Maxwell Underground Coal Mine Project (SSD-9526) - Adequacy of the Environmental Impact Statement (EIS).

I refer to the email dated 7 August 2019 inviting the Resources Regulator (Regulator) to provide advice regarding the adequacy of the Environmental Impact Statement (EIS) for the State Significant Development application for the Maxwell Underground Coal Mine Project (the Project).

Matthew Newton
Principal Inspector Environmental Rehabilitation
Resources Regulator
NSW Department of Planning, Industry & Environment

25 September 2019

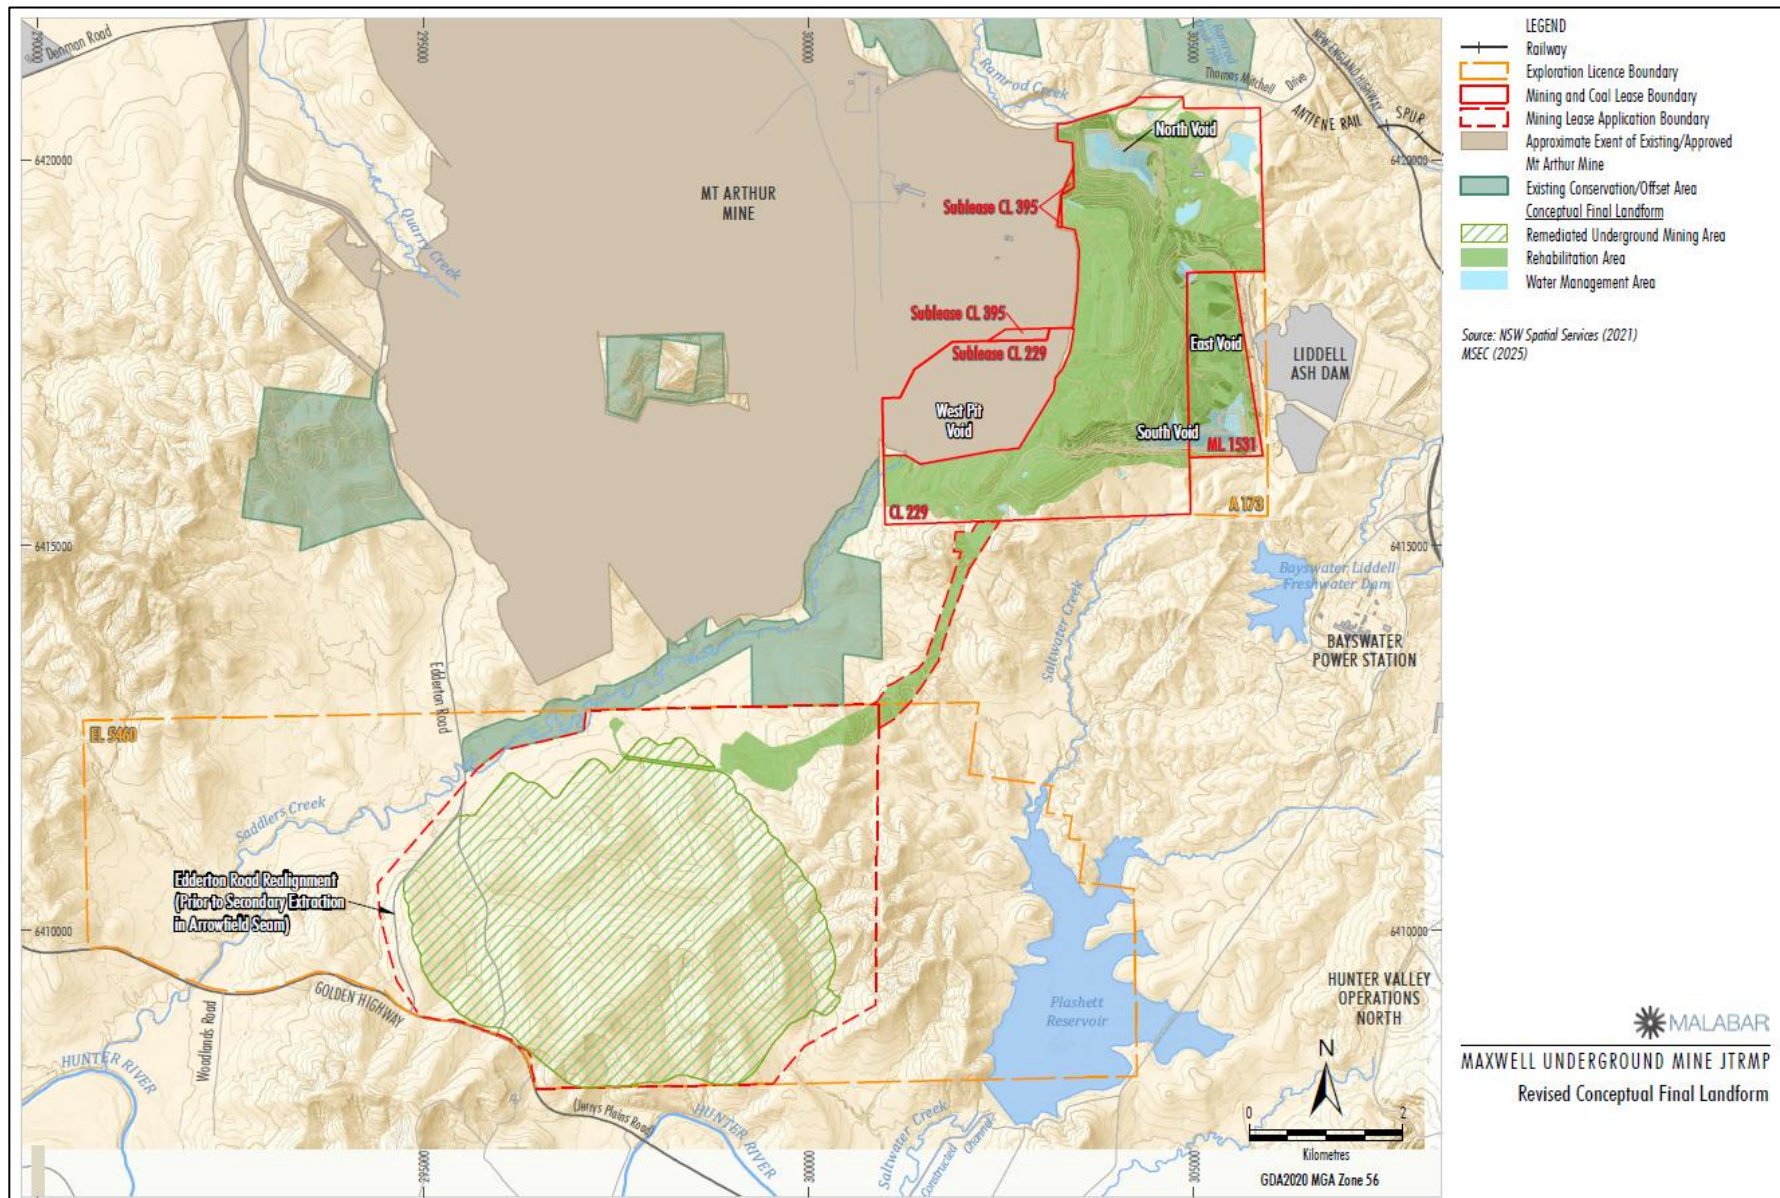
i. Conceptual final landform design

The proposed final landform (Appendix U, section 4.4 and figure 4) does not clearly depict final rehabilitation of waste emplacements and final voids. Further information is required to clarify:

- A clear description of landform design objectives
- Consideration of micro/macro relief and or variability in the landform design for remaining rehabilitation at the north void and south void (i.e. to integrate the rehabilitated highwall with adjacent rehabilitated landforms).
- Proposed final landform contours (at an appropriate interval) for rehabilitation areas and adjacent landforms.
